# CITY OF ALBUQUERQUE

**RE: VENTURA VILLAGE SUBDIVISION (C-20/D37)**  
**Engineers Certification for Release of Financial Guaranty**  
**Engineers Stamp dated 10/08/2002**  
**Engineers Certification dated 05/06/2005**

**Re: Ventura Village Subdivision Drainage Report**  
**Engineer's Stamp dated 10-8-02 (C20/D37)**

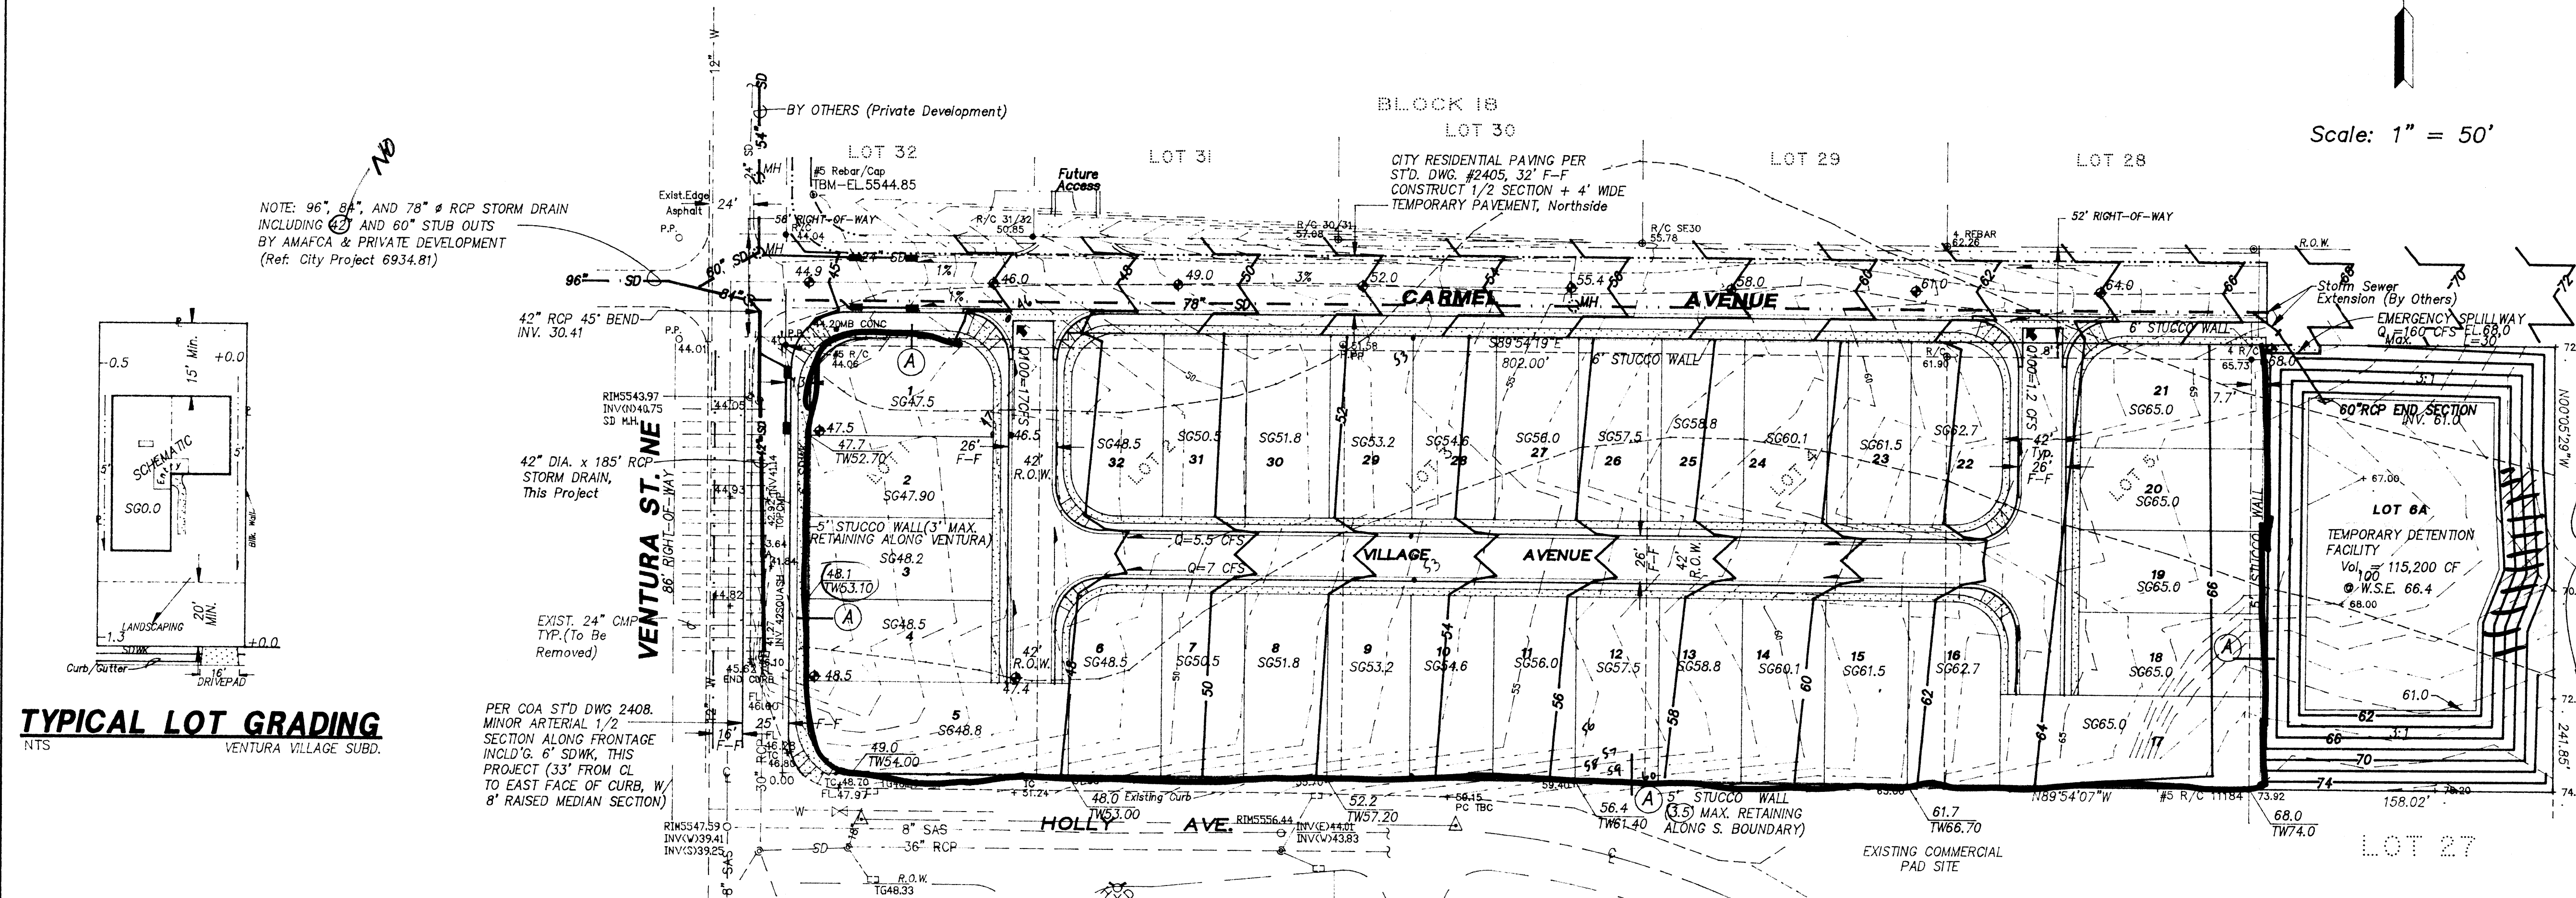
- A comprehensive, *bound* report including all calculations concerning street hydraulics (with actual depths), inlet capacity, offsite street flows (Carmel) will be required.
- The Work Order for the Carmel SD project (COA# 693481) must be let. (*Closed out 5/27/04*)
- No grading will be allowed on this site until the AMAFCA project is constructed and accepted.

Please find the revised grading and drainage plan addressing your comments dated 9/23/02. In sequential response please note the following:

- Added spot elevations on Ventura and Holly fronting perimeter wall @ top of wall locations, internal grade to wall + added existing spot elevs. In deed, since we will drain Lots 1-5 to the internal streets, a 3' retaining wall is verified along Ventura. (my office has coordinated with JMA (Graham Means) on the proposed vertical alignment of Ventura).

- Cross-lot drainage has been removed from the concept of the subdivision, and detail revised.
- The Carmel approach slope east to west is 1% for 100-150 feet before the intersection<sup>is</sup> proposed within a short, ½ vertical curve. The final intersection drainage will be determined during the DRC process and further coordinated with JMA in accordance with standard DPM criteria cited. Additionally, residual street flow upstream of the project has not been finalized by JMA.

- Please find a copy of the revised preliminary subdivision plat adding Tract 6A. Interim upstream drainage is addressed by adding an earthen "temporary" detention facility to be maintained by the developer incase the anticipated Don Hoech developments do not occur.

- Our project remains contingent upon the Carmel Ave./AMAFCA joint venture storm drain trunk line, but does not assume collection thereto. Therefore, the Tr. 6A pond is required.
